CITY OF ALBUQUERQUE

**Re: San Clemente Apartments Buildings C and D,
204 and 206 San Clemente Ave NW, Traffic Circulation Layout
Engineer's Stamp dated 10-12-12 (G14-D006A)**

Based upon the information provided in your submittal received 10-15-12, the above referenced plan cannot be approved for Building Permit until the following comments are addressed:

EXHIBIT "A"
TRAFFIC CIRCULATION LAYOUT

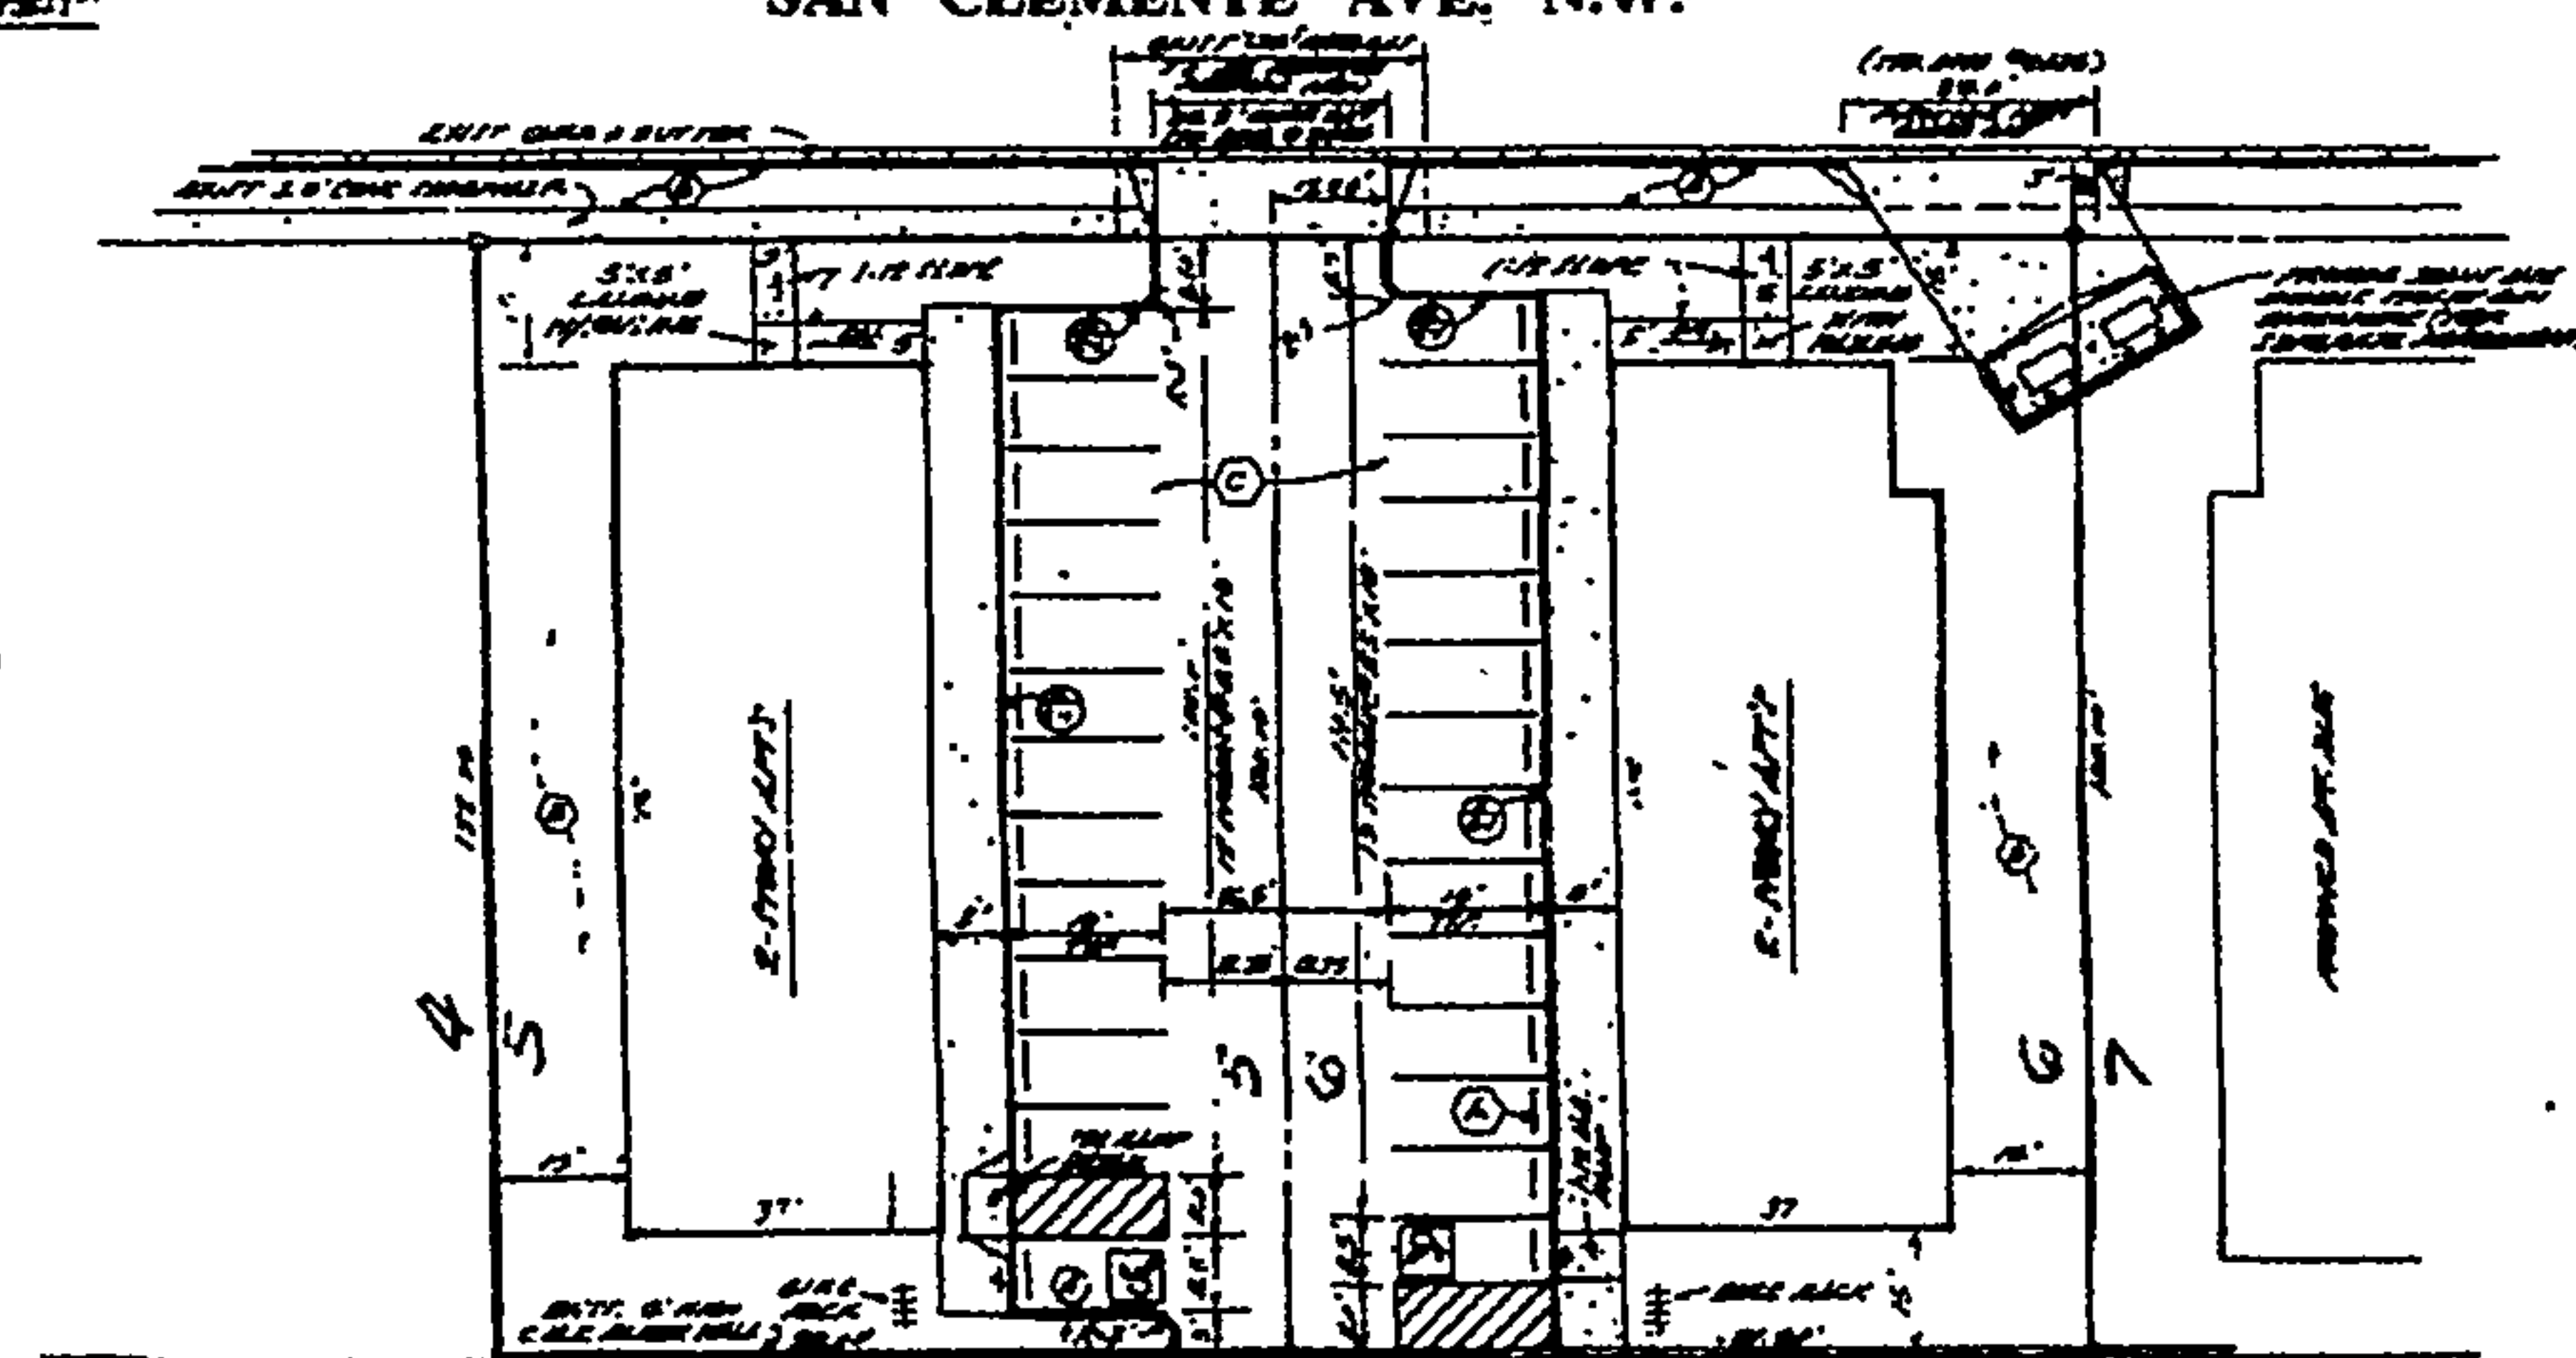
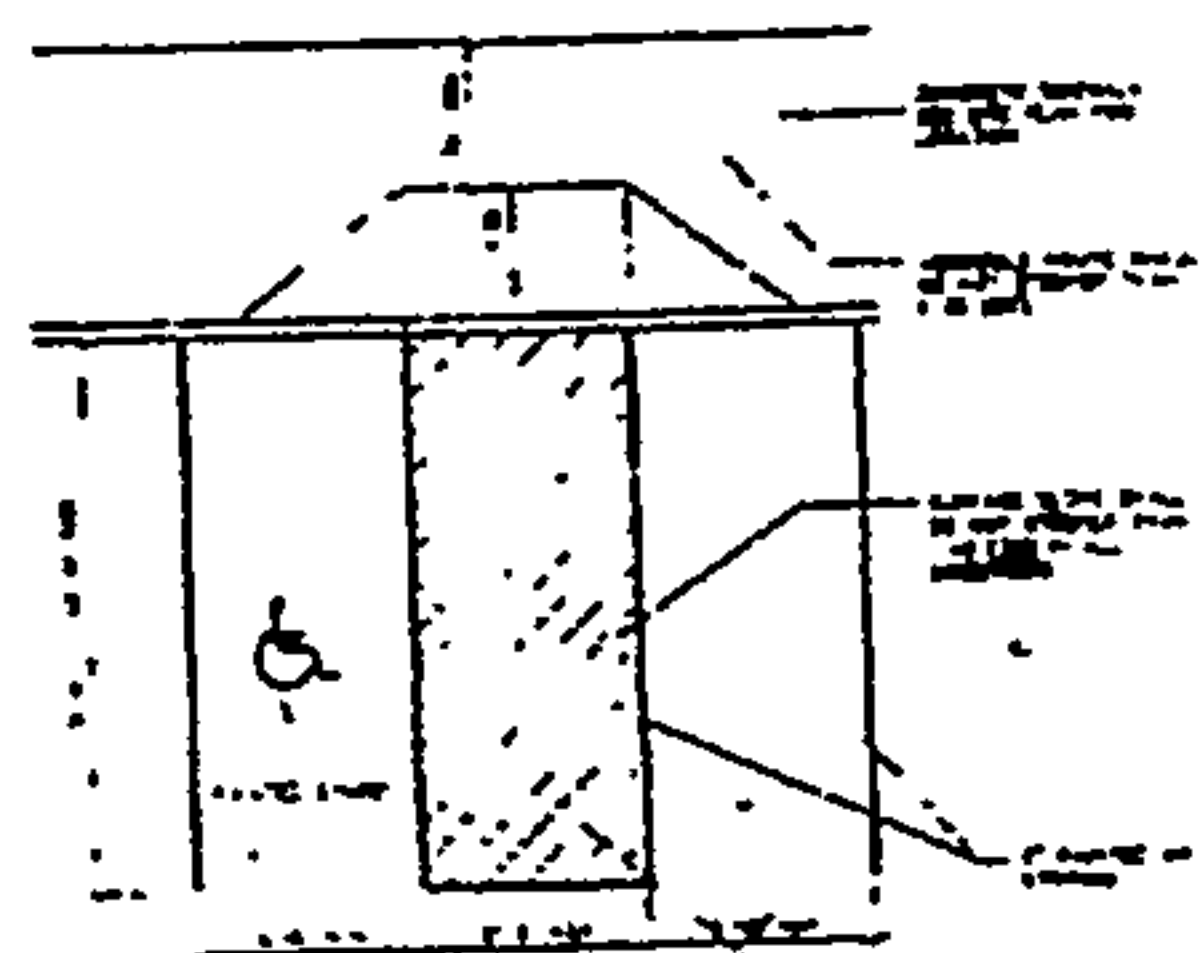
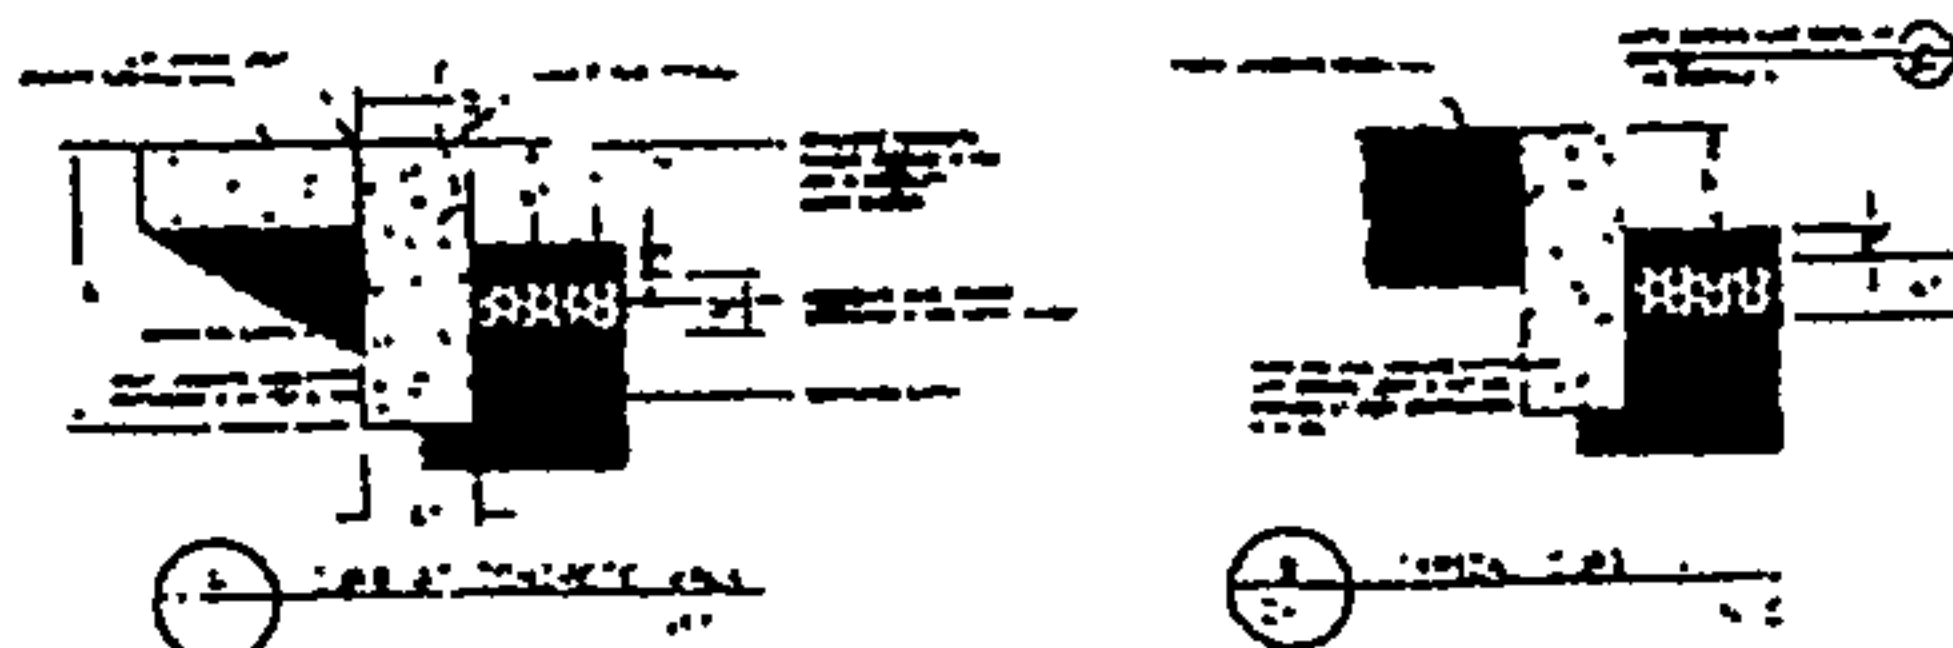
1. Provide a copy of the shared access agreement between lots 5 and 6.
2. Recent aerial information shows no sidewalk along this frontage; please clarify.
3. The proposed 3-foot high screen wall (keyed note D) appears to interfere with the sight distance for the entrance. Provide a sight distance exhibit. Please note that walls, trees, and shrubbery over 3 feet tall (measured from gutter pan) will not be acceptable in this area.
4. The proposed 3-foot high screen wall (keyed note D) blocks the ADA pathway from the roadway to the buildings. Please clarify.
